From: Jeremiah Bartlett
To: Fraser, Jean
CC: Errico Thomas
Date: 7/23/2015 2:00 PM
Subject: ? as to whether to require a crosswalk Fwd: Re: 81 Industrial Way

SHEET 3 OF 7

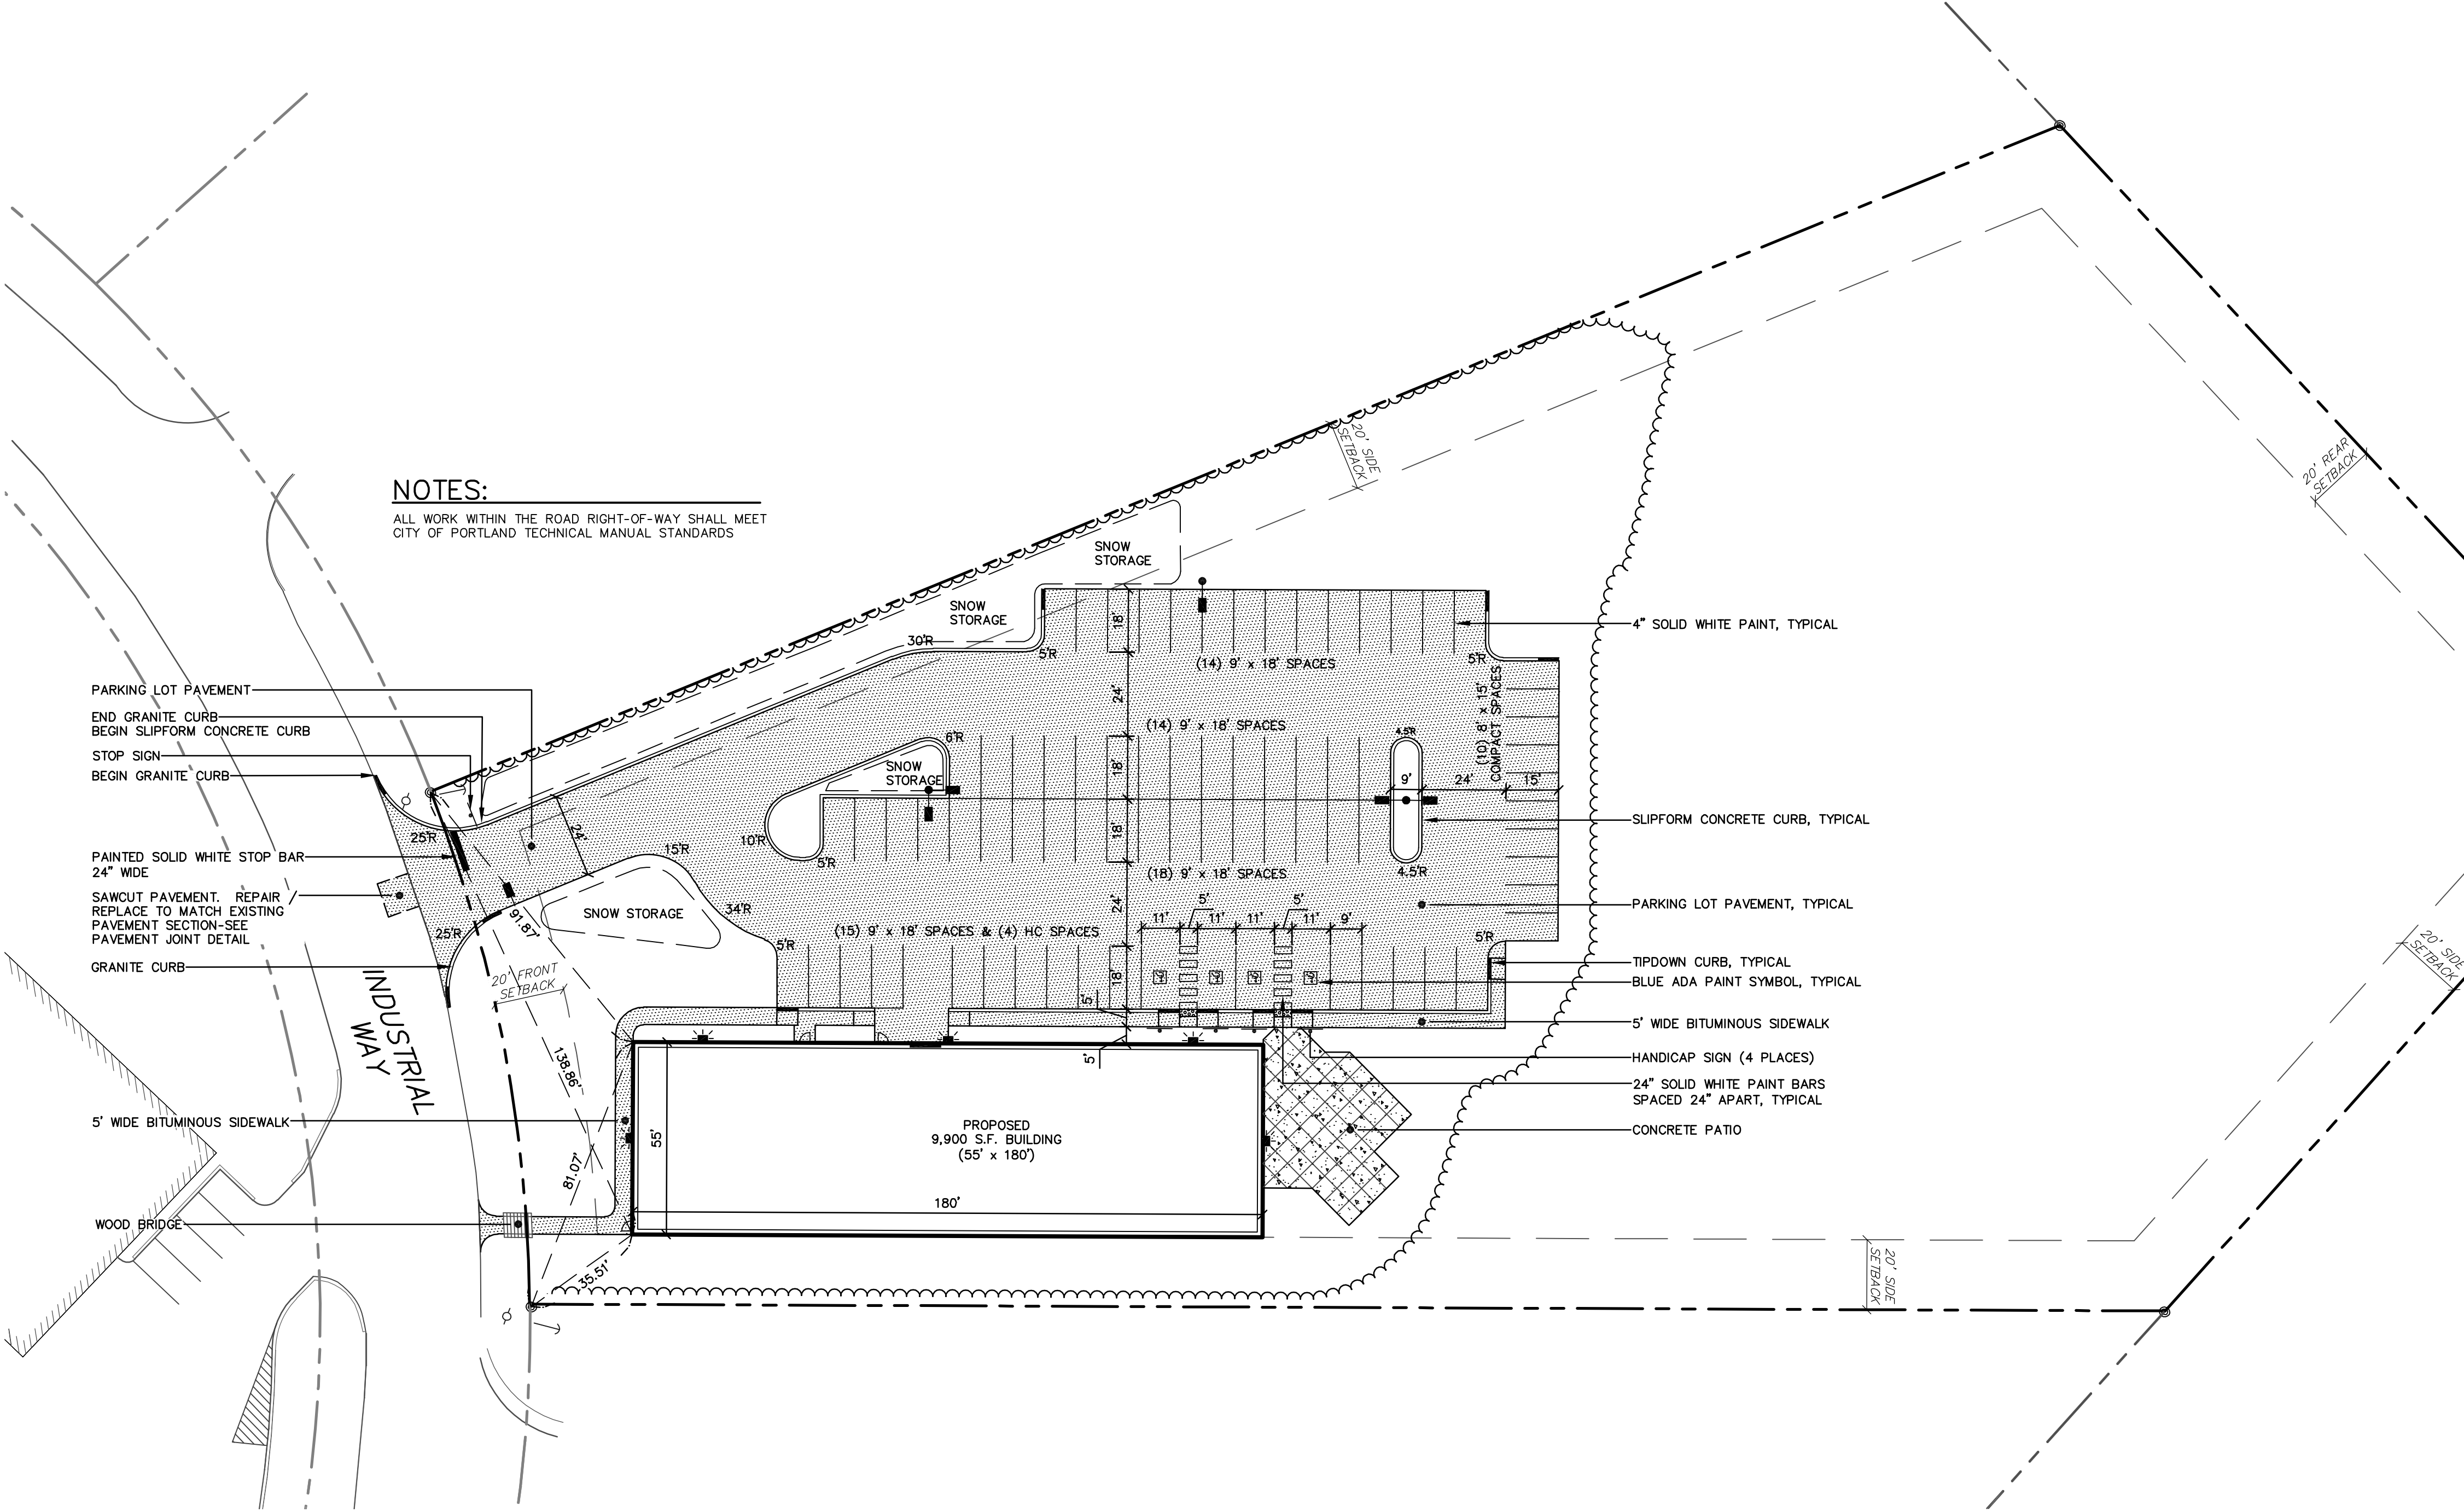
I concur with Tom that a crosswalk is not required, and, indeed, due to the lack of supporting facilities, likely should not be allowed.

There are no sidewalks or curbs on Industrial Way and the policy has been confirmed that we will not be requiring those (long story). I agree with Tom (that we should not require a crosswalk) because to invite people to walk at that bend does not seem a good idea. This is an industrial area but increasing there are offices and members of the public going on brewery tours.

The sketch just indicates a location but I am not sure about sightlines etc and we probably need to give them guidance on what we want in terms of a detailed design- would this need to go to the crosswalk committee? Should I be cc'ing Bruce or others?
